**Washington State  
Department of Transportation**

February 5, 2014

Subject: DNS 14-005: Yakima Highway 10 Access  
SR 10 milepost 101.1 right

# Staff Photos—Aerial Map

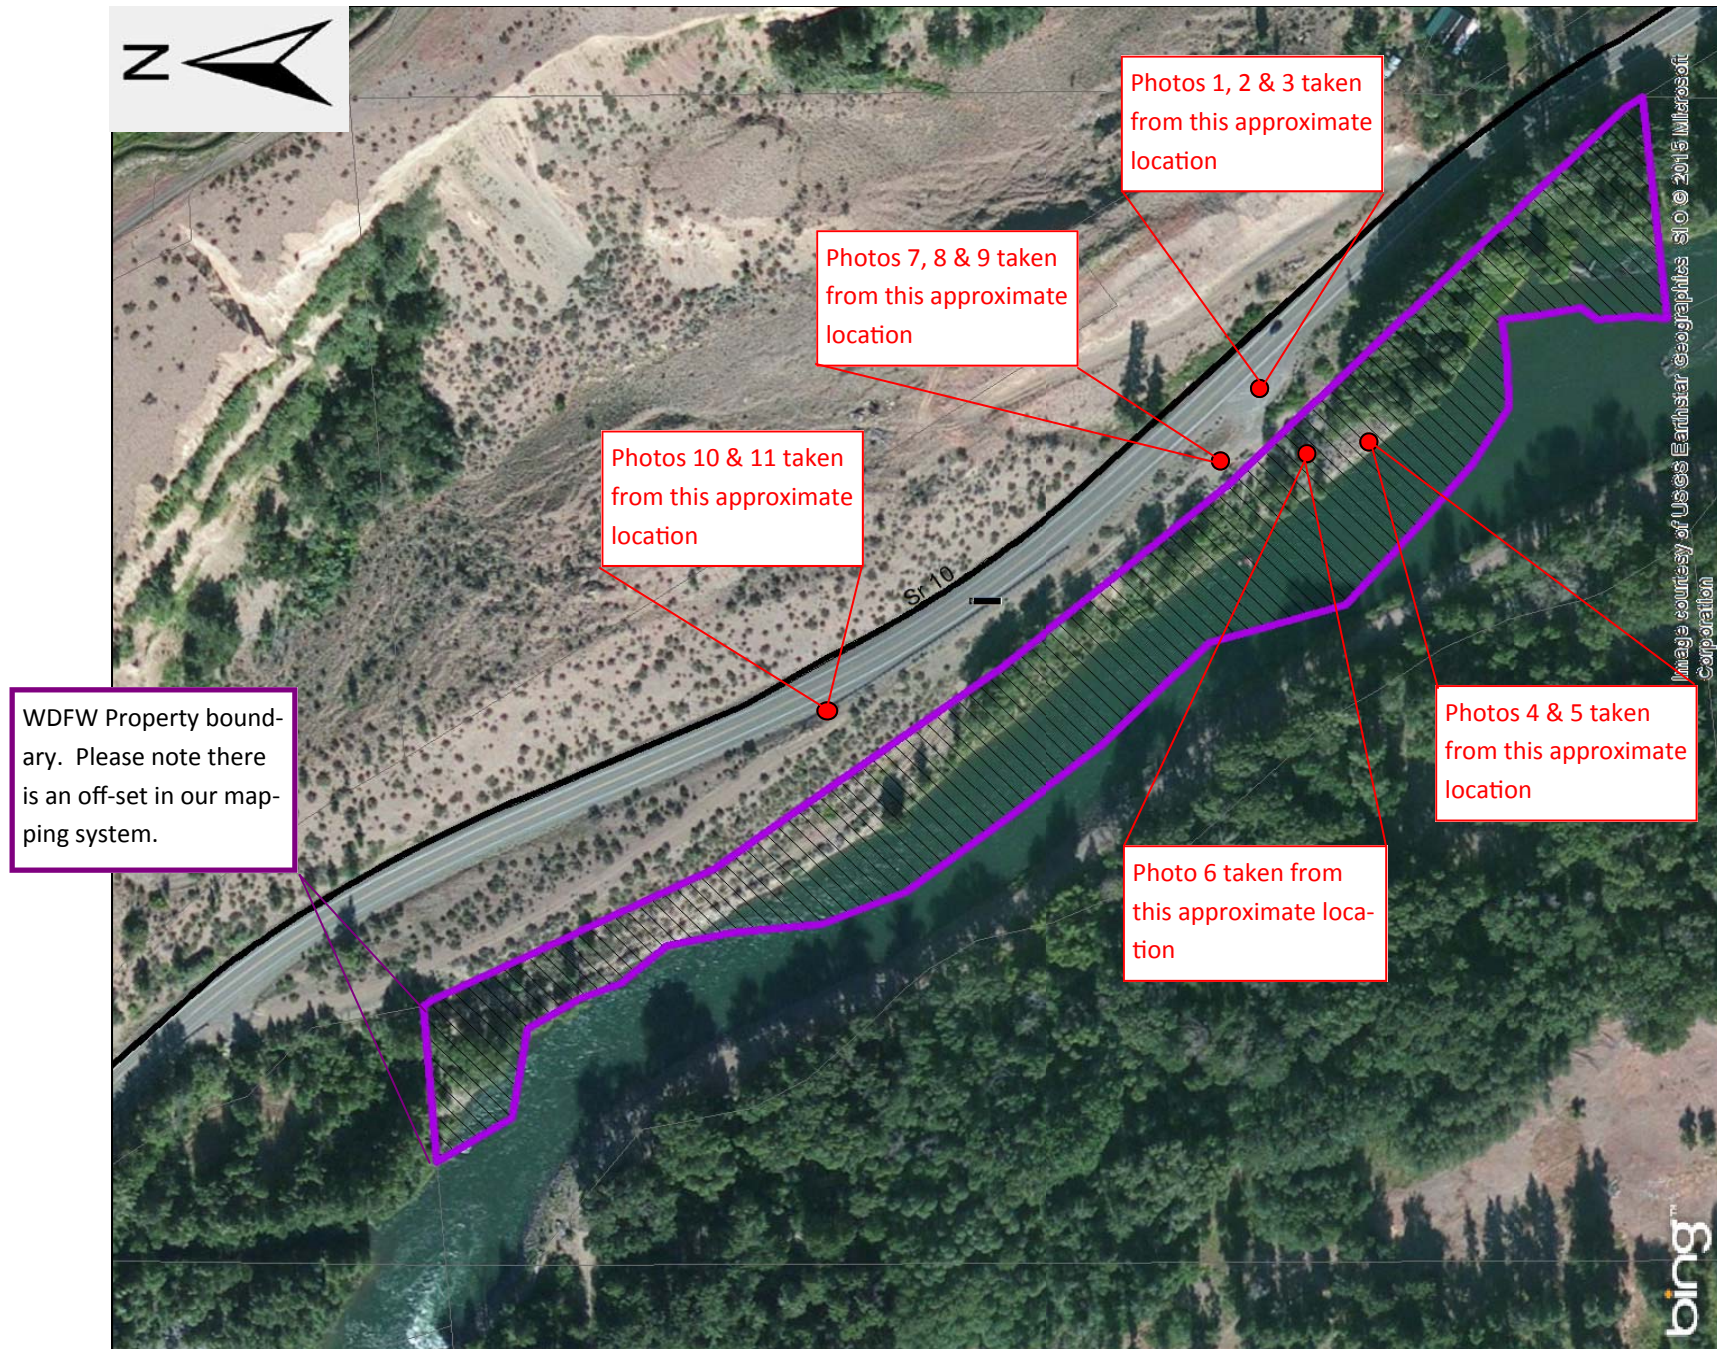
- The parking lot configuration shown in the review documents has been significantly changed from the conceptual considerations. WSDOT has concerns with placing new features, including parking stalls, within clear zone. The previous parking configuration reviewed by WSDOT is more suitable for avoiding clear zone issues and mitigation. The proponent is required to contact this office to discuss the geometrics of alternate solutions.

Thank you for your comments on the DNS 14-005 Yakima Hwy 10 Access project. The project manager on this project, Rusty Gigstead, will contact the office to discuss the geometrics of alternative solutions and designs. An airspace lease and access connection permit will both be obtained before work begins on the project. WDFW appreciates your support of the project and we look forward to working with you.
